**RIVERBEND RESIDENTIAL  
DEVELOPMENT**  
**PRELIMINARY GRADING PLAN**

DESIGNED BY:	DLM	DRAWN BY:	DBM
SCALE:	1" = 100'	DATE:	01/29/20
JOB NUMBER	17-114	SHEET	3 OF 3

COUNTY FILE NUMBER: PCD File No. SP187

SHEET NUMBER  
S-1  
1 OF 3 SHEETS  
COUNTY FILE NUMBER:  
PCD File No. SP187

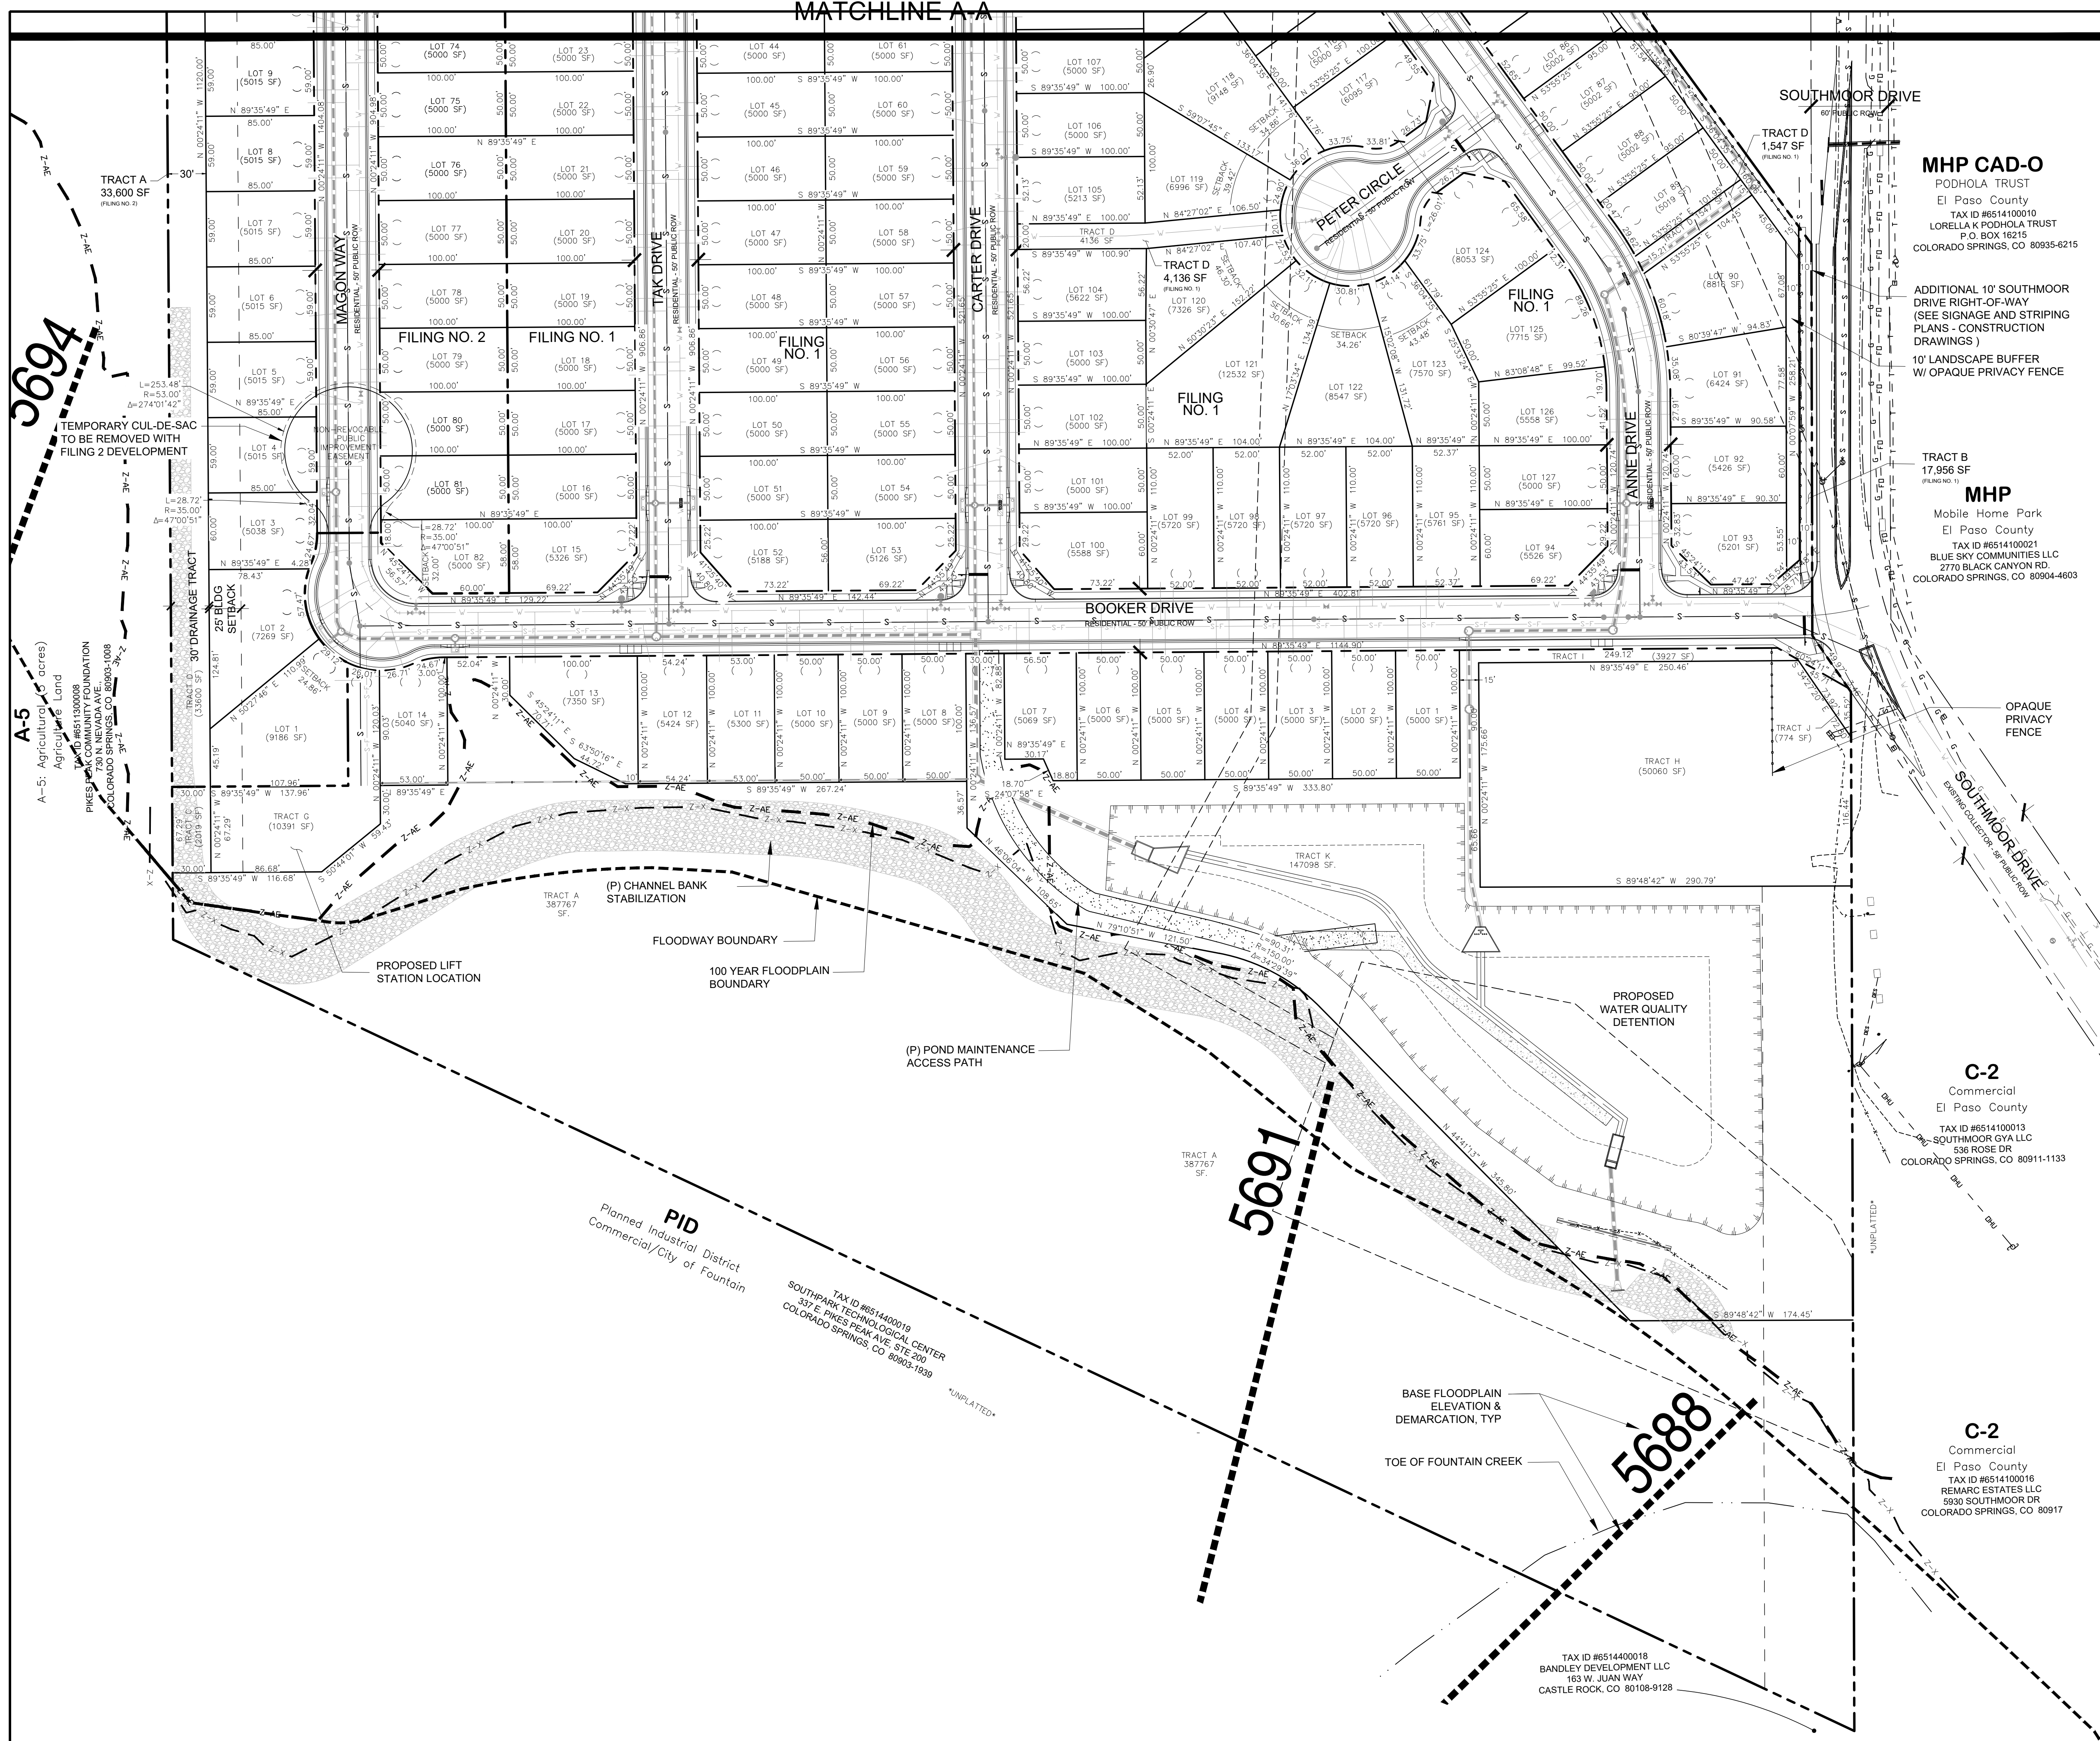
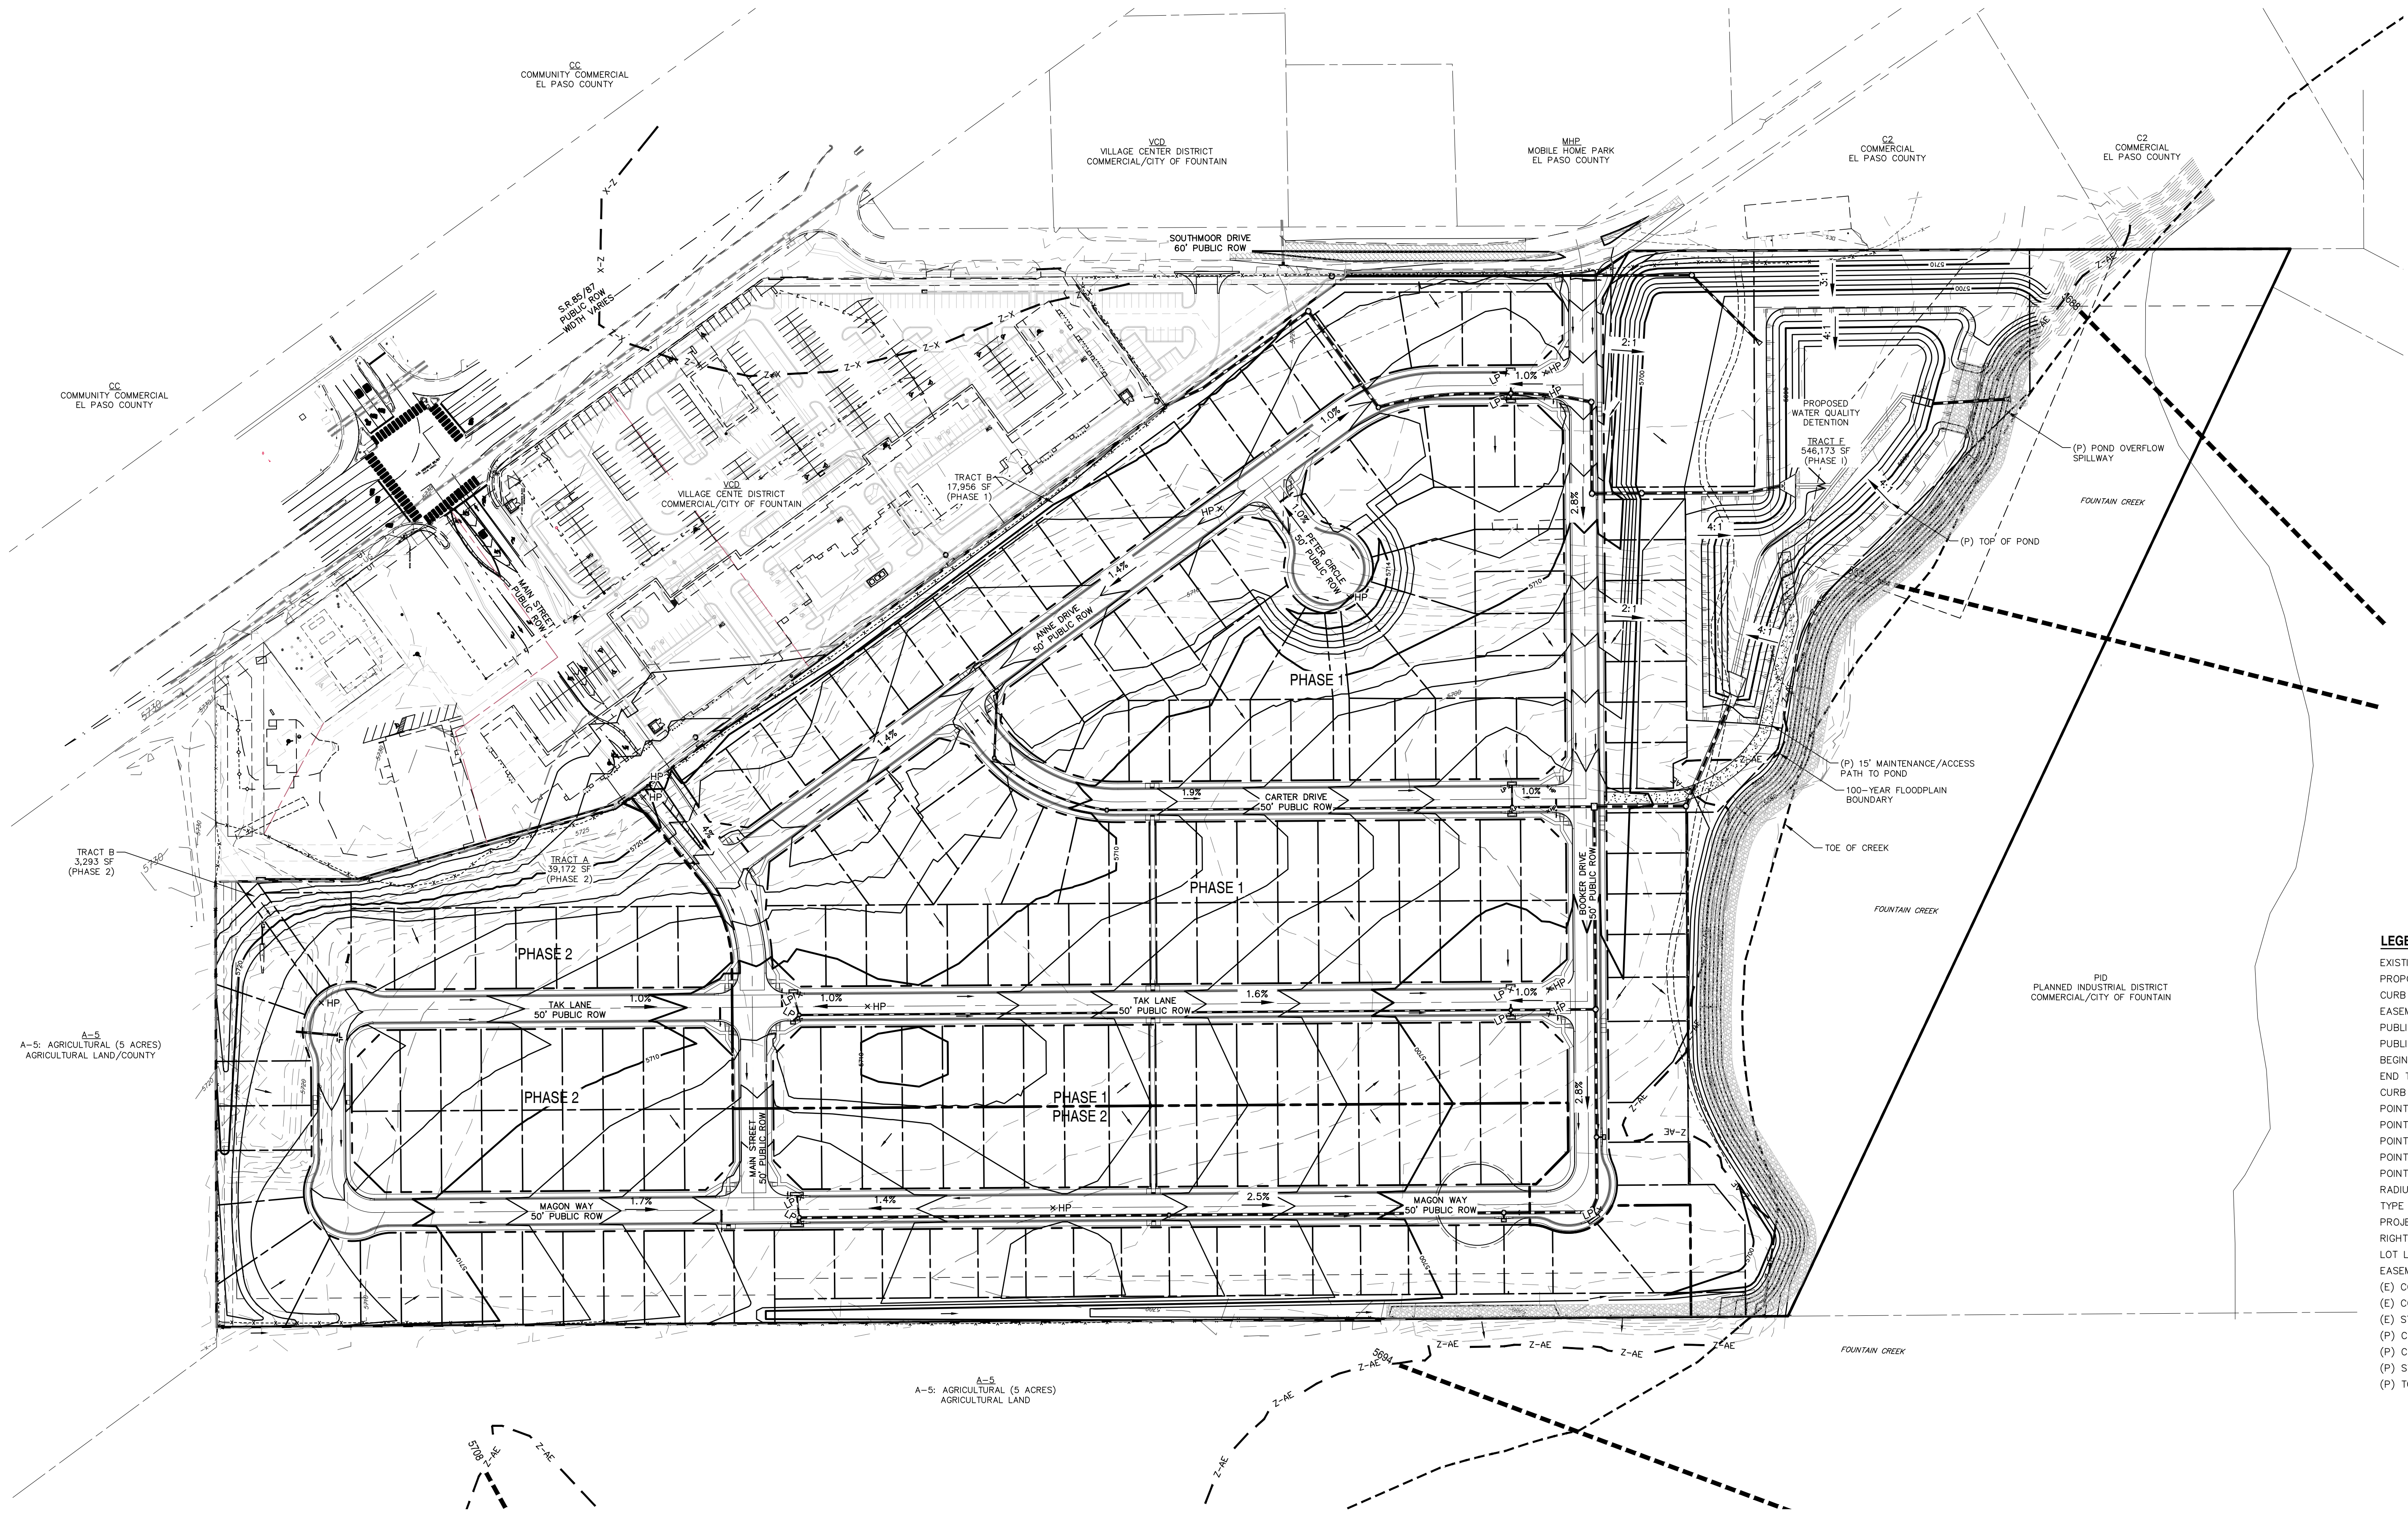
Provide midblock ramps. Update the preliminary plan and construction plans accordingly. See criteria below.

**4. Mid-Block Ramps on Local Roadways**  
Access ramps on local roadways shall be spaced no greater than 600 feet apart. Where spacing is greater than 600 feet, mid-block access ramps shall be provided at spacings that minimize travel distances between access ramps. Private accesses may be used for these access points where the access is designed to meet access ramp requirements. The pavement markings and signing required by the ECM and MUTCD shall be provided for mid-block access ramps.
